From: Brian Horan, PE, PTOE
Galloway

Date: November 22, 2024

Re: Comment Response to “Carlisle & I-40 Traffic Impact Study”

This memorandum serves as a comment response to comments provided by the City of Albuquerque and NMDOT regarding the Carlisle & I-40 Traffic Impact Study (TIS) dated July 1, 2024. City comments on the TIS are dated July 22, 2024 and are included below in *italics*. NDOT comments on the TIS are dated September 16, 2024 and are included below in **bold**. Our **response** is provided below each comment.

FIGURE 1-2
SITE PLAN

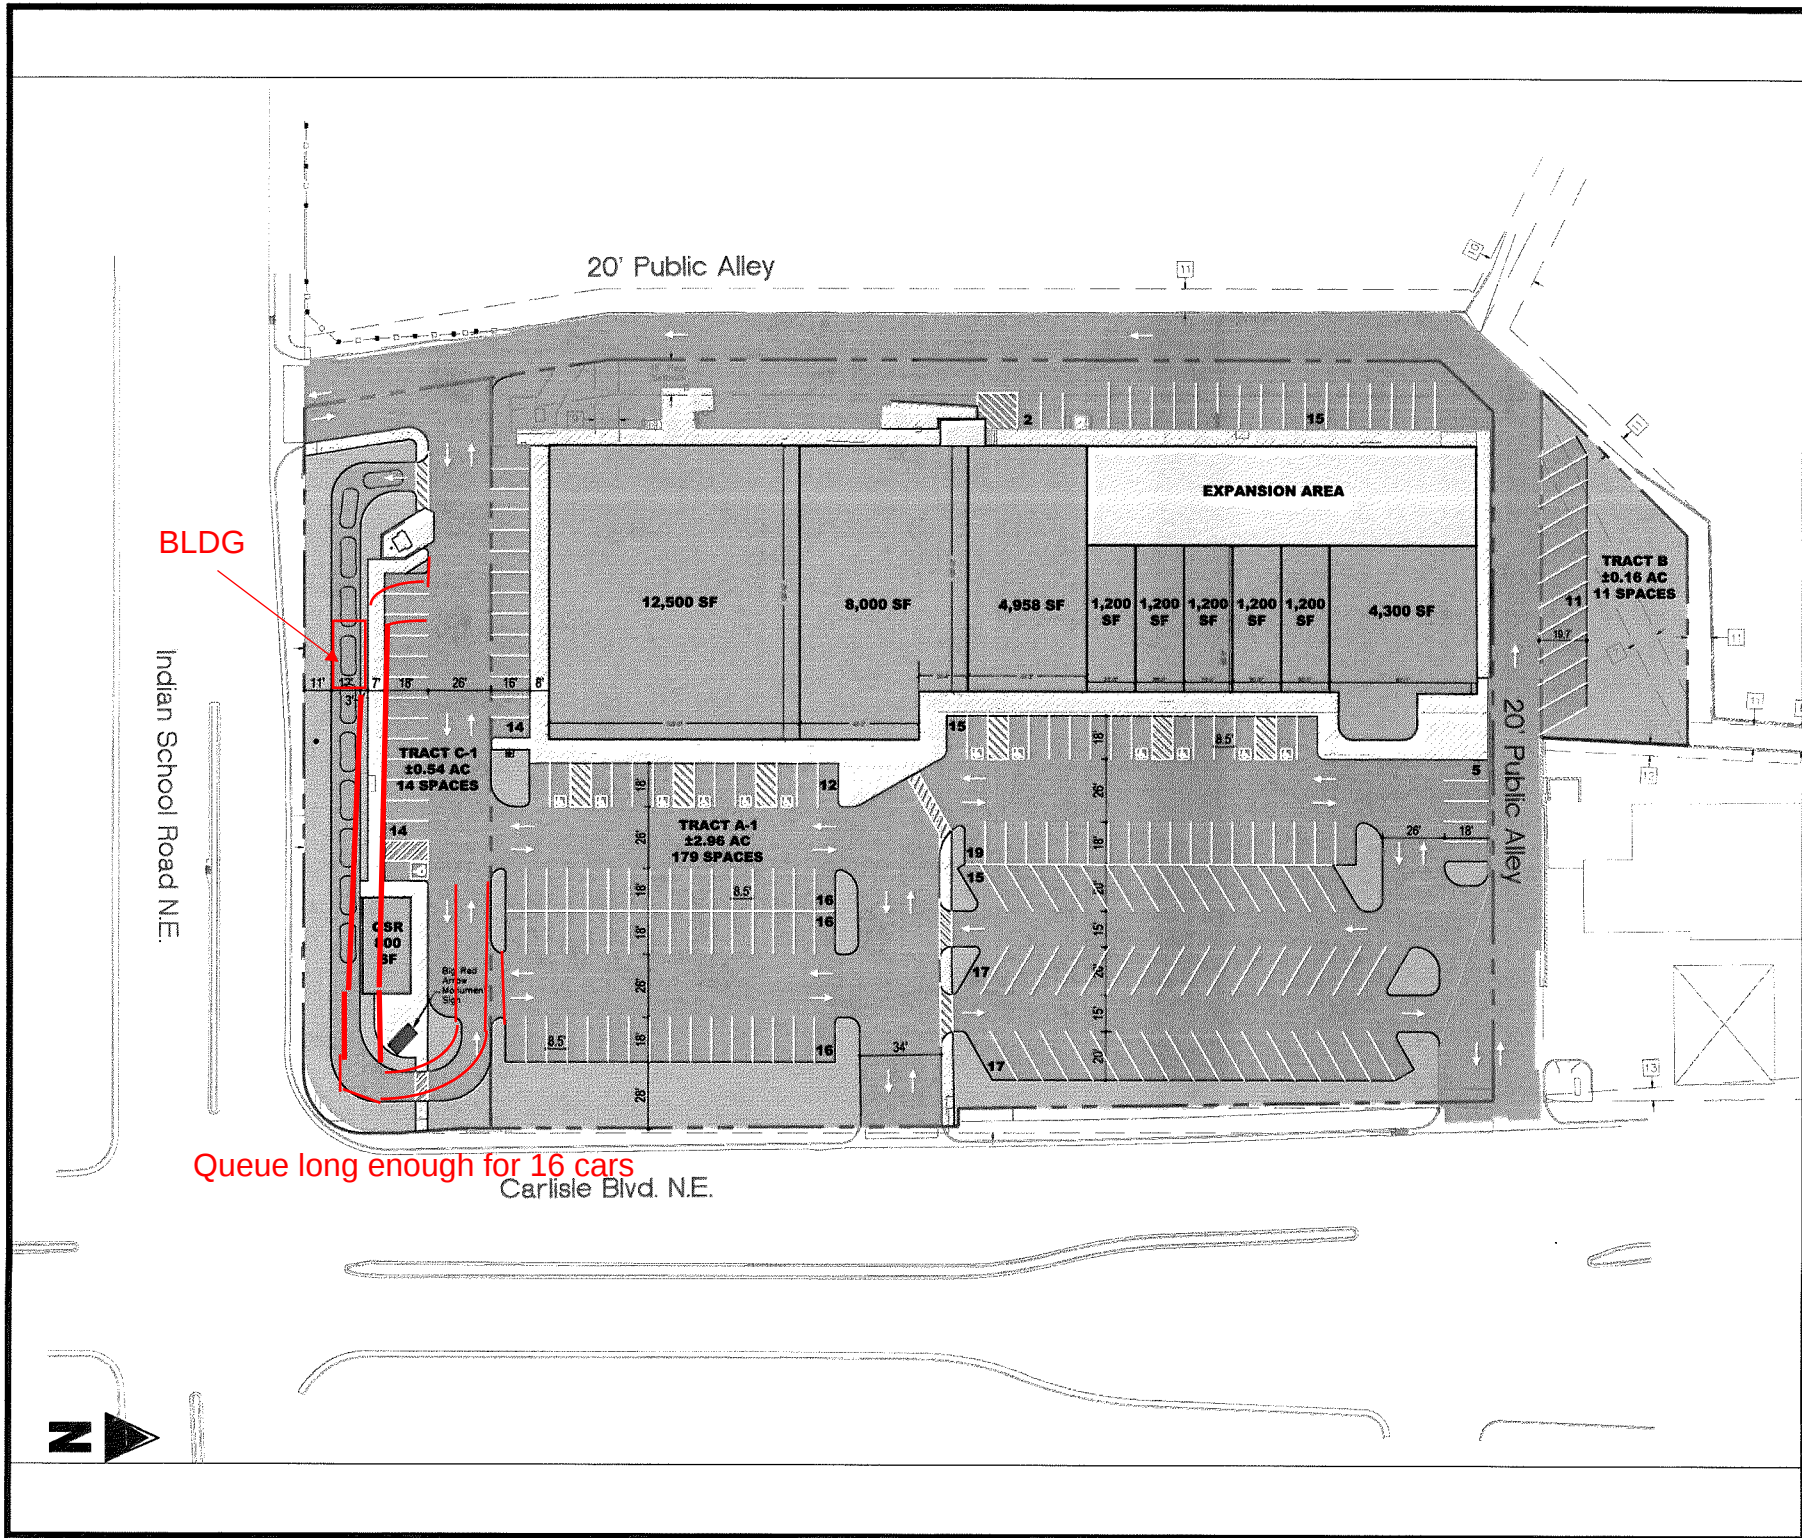
For the drive-through land use, the City has a minimum queue of 16 vehicles and sometimes that isn't sufficient. It is not desirable to have the queue back-up onto Indian School Rd. A meeting was held with Wes Butero on 7-19-24 to discuss the redesign of the drive-through. Include the revised Site Plan in the Study.

Response: Site plan revised per discussion stated above. TIS updated to include revised site plan.

TRAFFIC CONTROL SITE PLAN

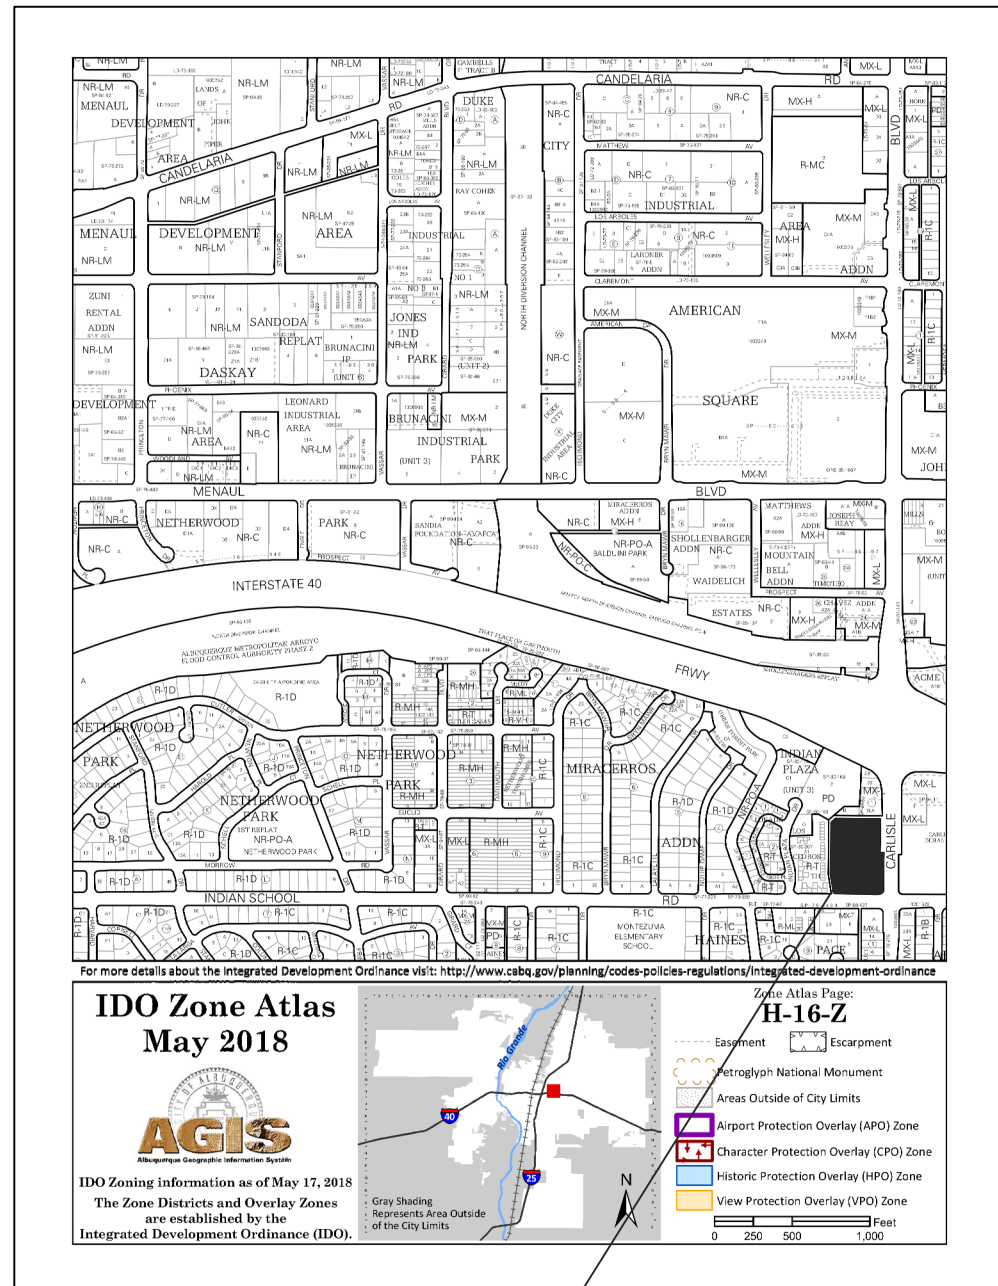
What is the reason for proposing the City's alley to be one-way? The 20' width is acceptable for 2-way traffic. How may this impact the use of Tract B? is there a planned use for Tract B? If the pavement markings in the alley are approved, it seems appropriate for them to be maintained by the Owner of Tract A-1.

Response: Site plan updated per comments and subsequent discussions with the city.

CARLISLE BOULEVARD NE-EXISTING CONDITION - SECTION A

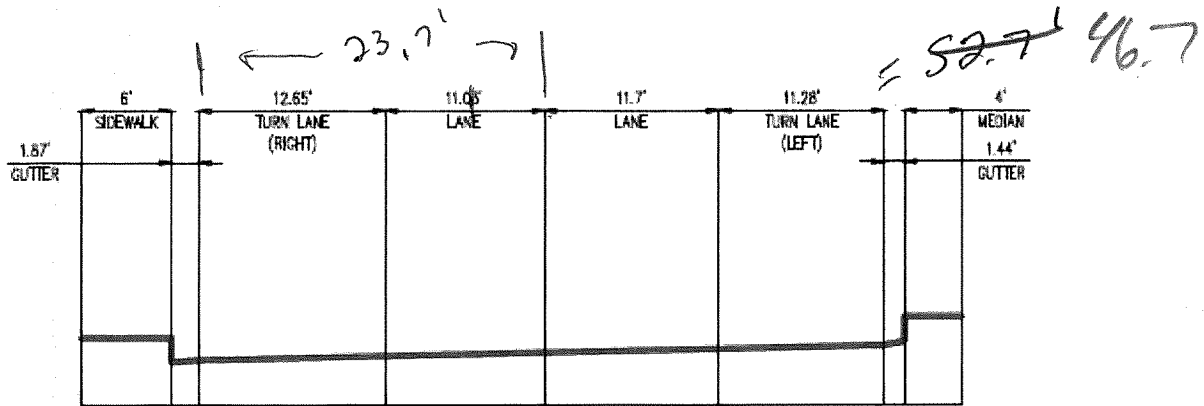
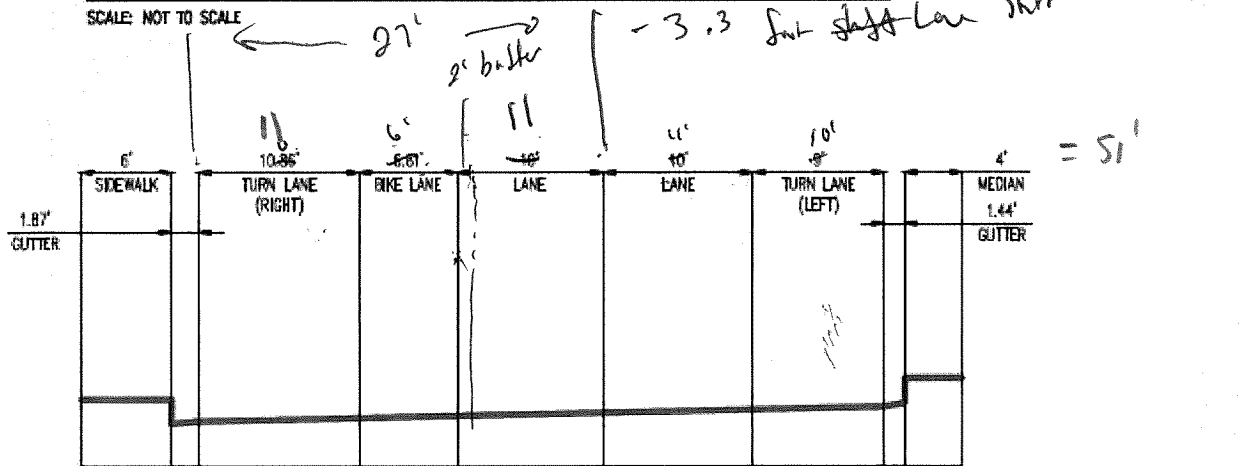
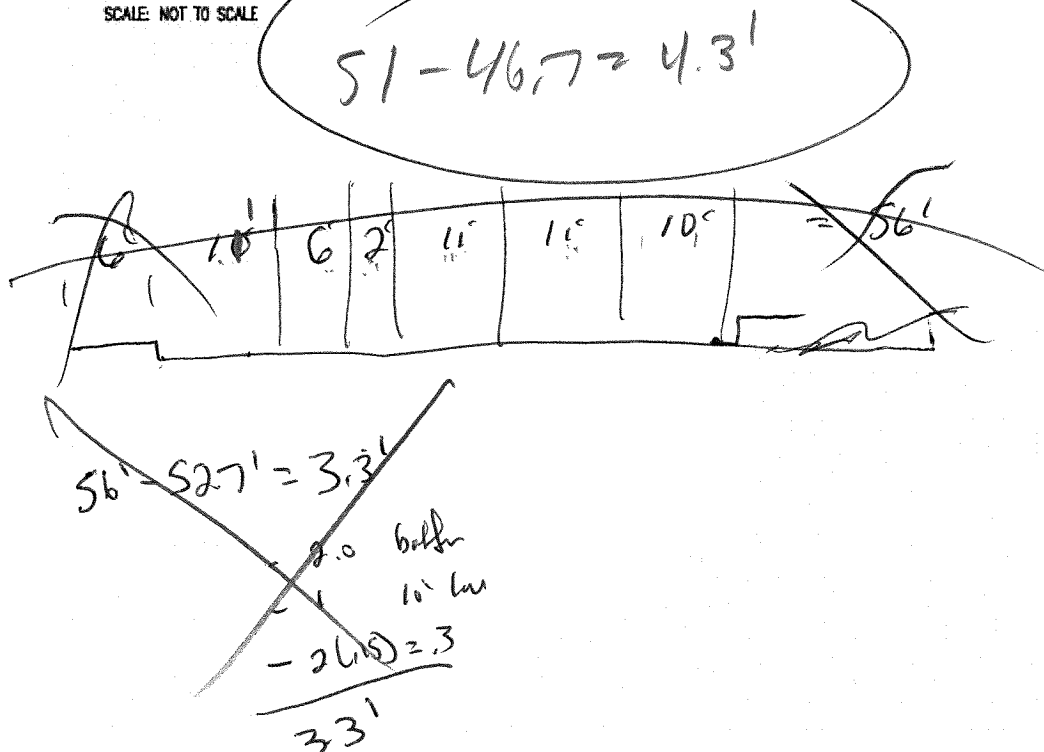
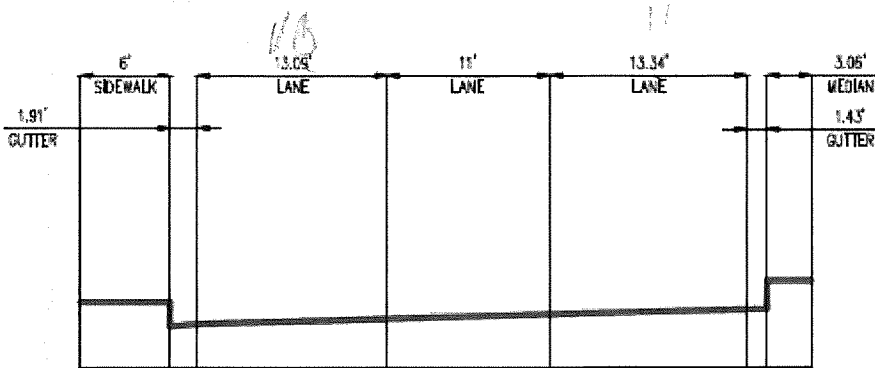
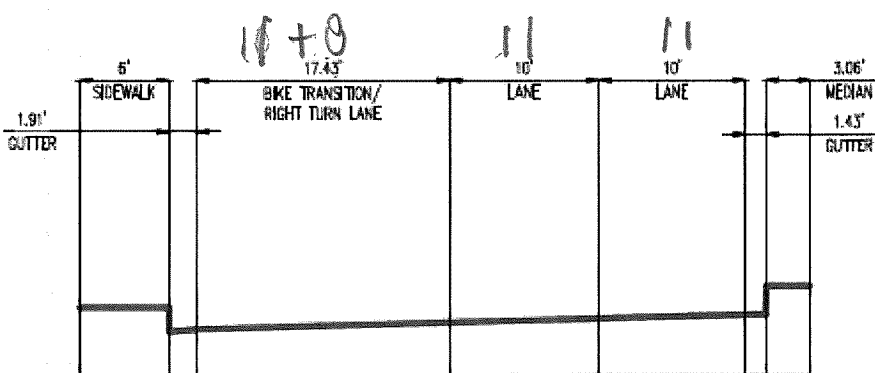
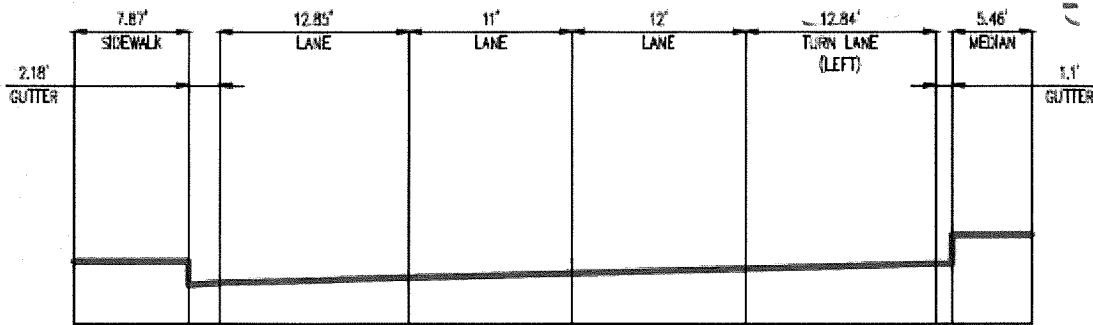
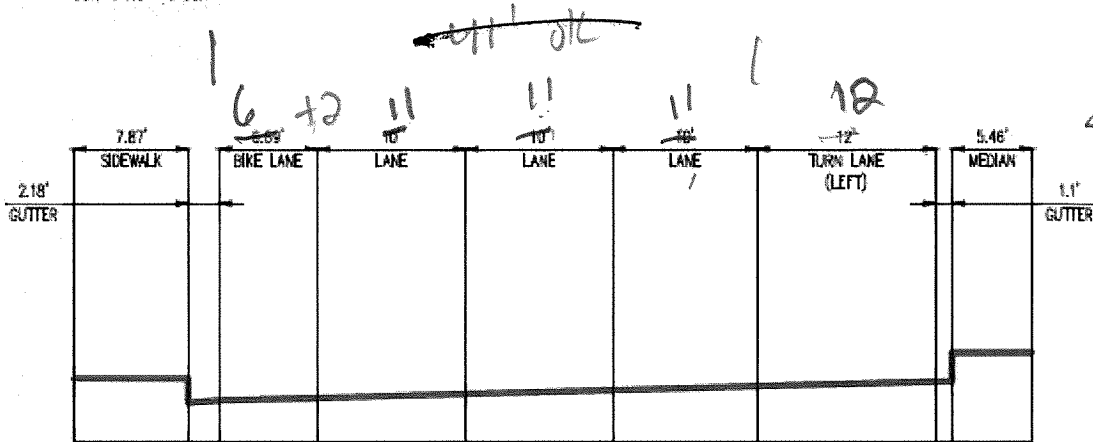
Provide an exhibit with a plan and section of Carlisle Blvd that shows the existing and proposed striping. The curb fronting this development may need to be relocated to the west to accommodate the bike lane. This may change the recommendation for the sidewalk on Carlisle Blvd to remain.

Response: Exhibit provided in Appendix A of updated TIS.
